RE: KAVANAGH OBJECTION to SSD-10394
ST JOHN OF GOD RICHMOND HOSPITAL REDEVELOPMENT
Lot 11 in DP 1134453, 235 Grose Vale Road, North Richmond

This letter of objection is prepared on behalf of Eugene and Debbie Kavanagh who reside on the farmland immediately south of the State Significant Development Application St John of God Hospital site at North Richmond.

07 SOUTH ELEVATION  
SCALE: 1:200

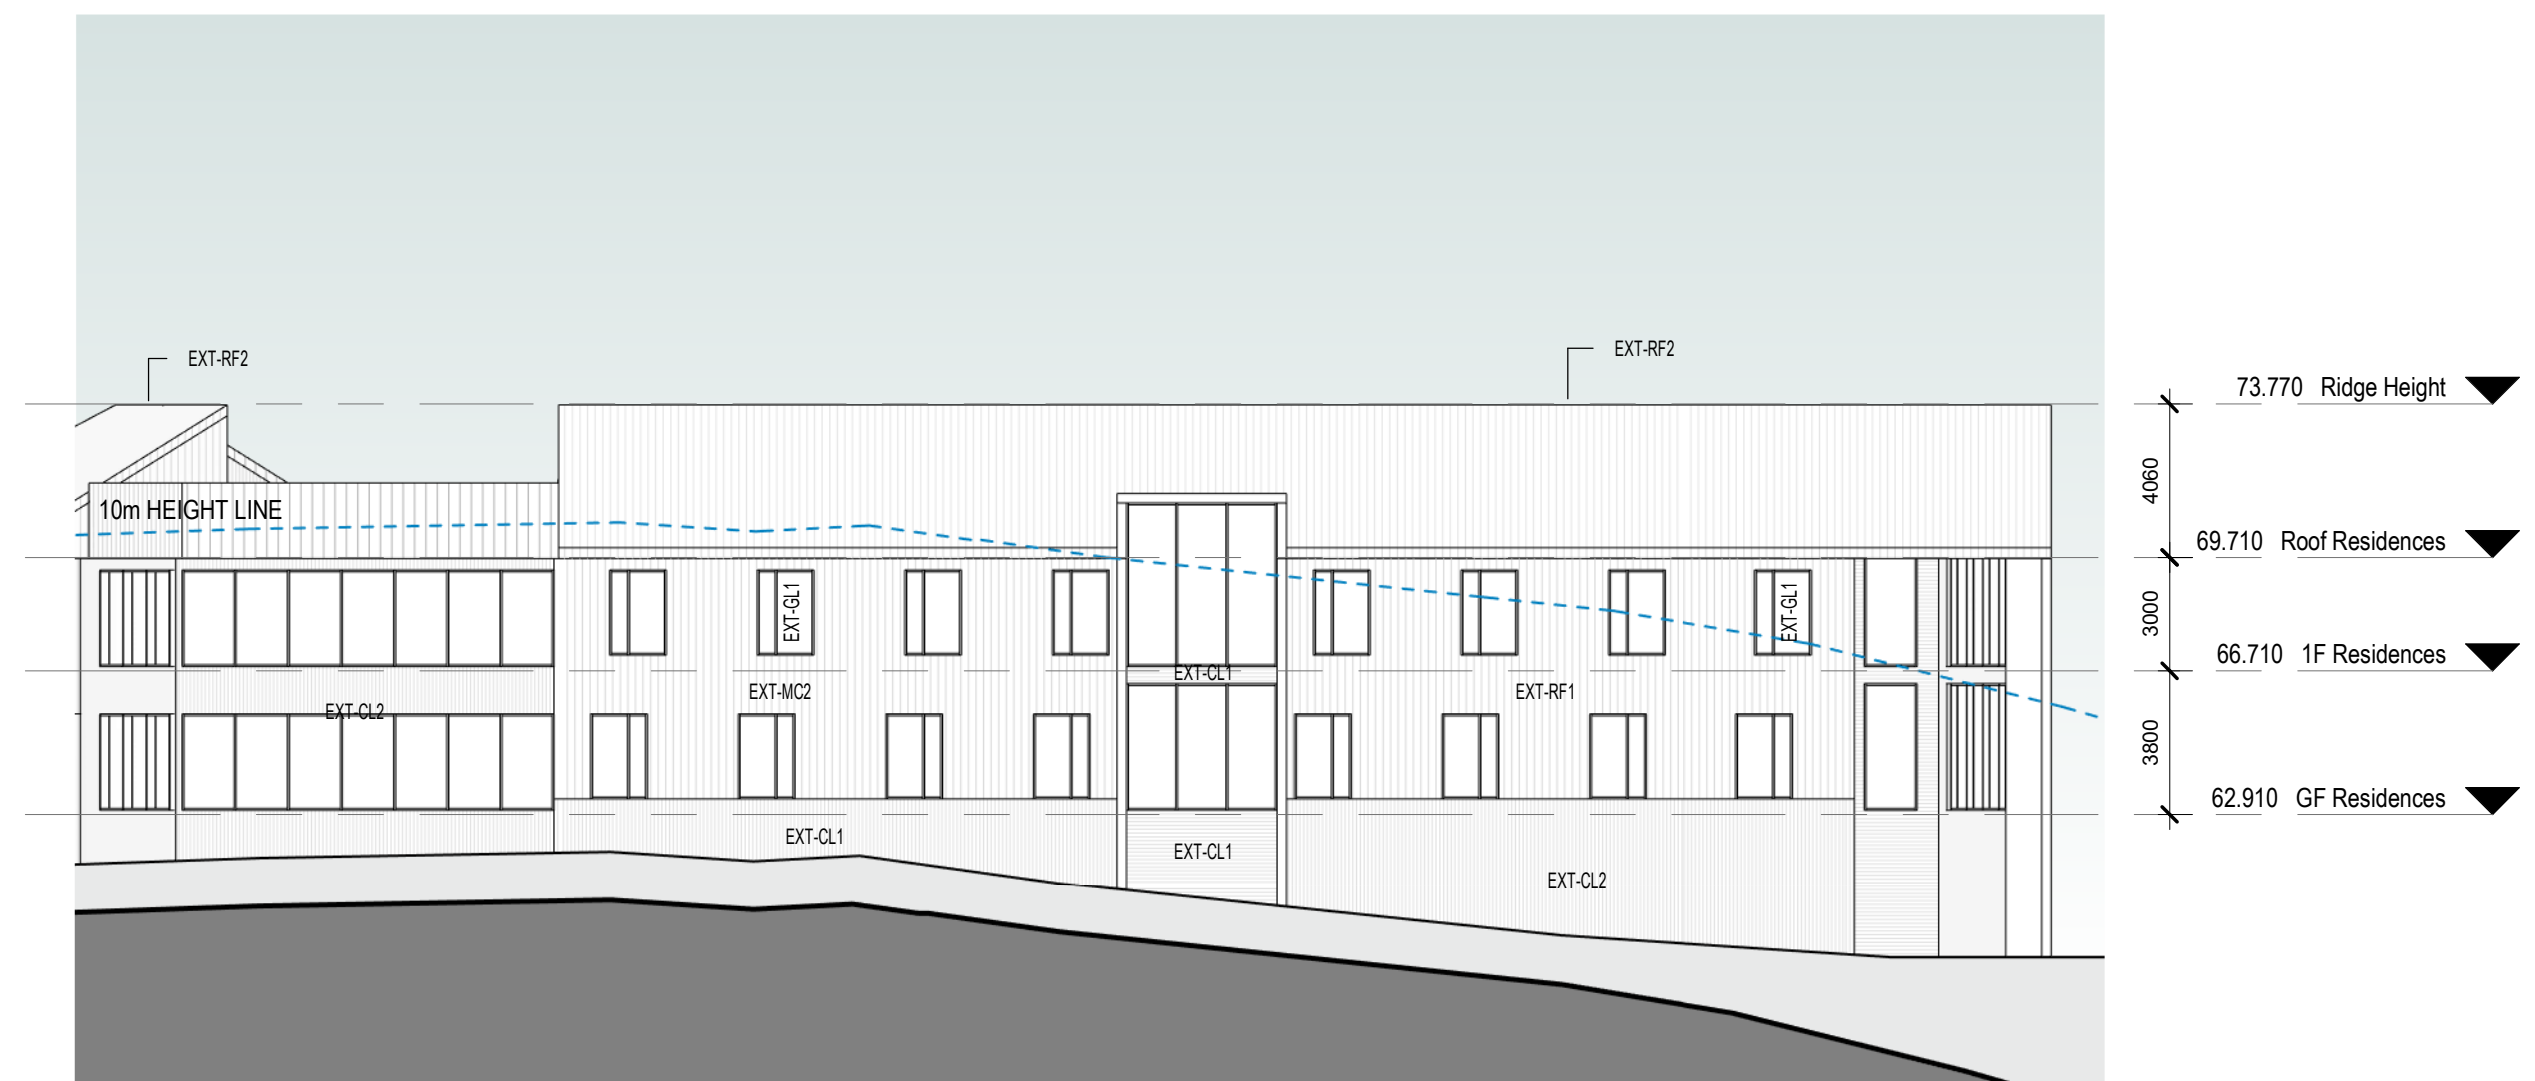
The non-complying southern elevation of the redevelopment will present as a domineering form from the Kavanagh’s property, due primarily to the proposed voluminous and high-pitched roof, combined with an elevated finished ground floor level for the four residential pavilions that will sit above natural ground level along a majority of the residential pavilion length.

Cross Sections 7 and 8 as extracted below illustrate how the proposed height non-compliance is a result of these few unreasonable design choices and which non-compliance could easily be rectified by setting the 4 pavilions at a lower natural ground level, reducing fill and/or subfloor areas and determining to adopt a lower pitched, skillion or relatively flat roof form.

Aspects of proposed hospital build that add significantly to the height non-compliance and overall bulk and scale of the proposal when viewed from adjacent farmland and the farm house and which height will also compete unnecessarily with the Belmont House roof line

A reasonable reduction to the proposed pitched roof coupled with a drop in the ground floor level through additional minor site excavation at the higher end of the pavilions and a reduction on subfloor area could be agreed in order to achieve full and/or more substantial compliance with the LEP height control. These are all relatively modest changes that can be achieved without impacting on proposed hospital bed numbers, preferred internal floor to ceiling levels or the preferred floor plan and disabled access outcomes.

Setting the ground level closer to or just below natural ground level at the higher end of the southern part of the site would drop overall roof ridge heights considerably in this area, reduce the visual dominance of the new residential pavilions as viewed from the Kavanagh's farm but also internally, would reduce the height non-compliance and avoid the need for fill and/or large subfloor areas and/or associated retaining walls on or near the southern boundary and excess building bulk.
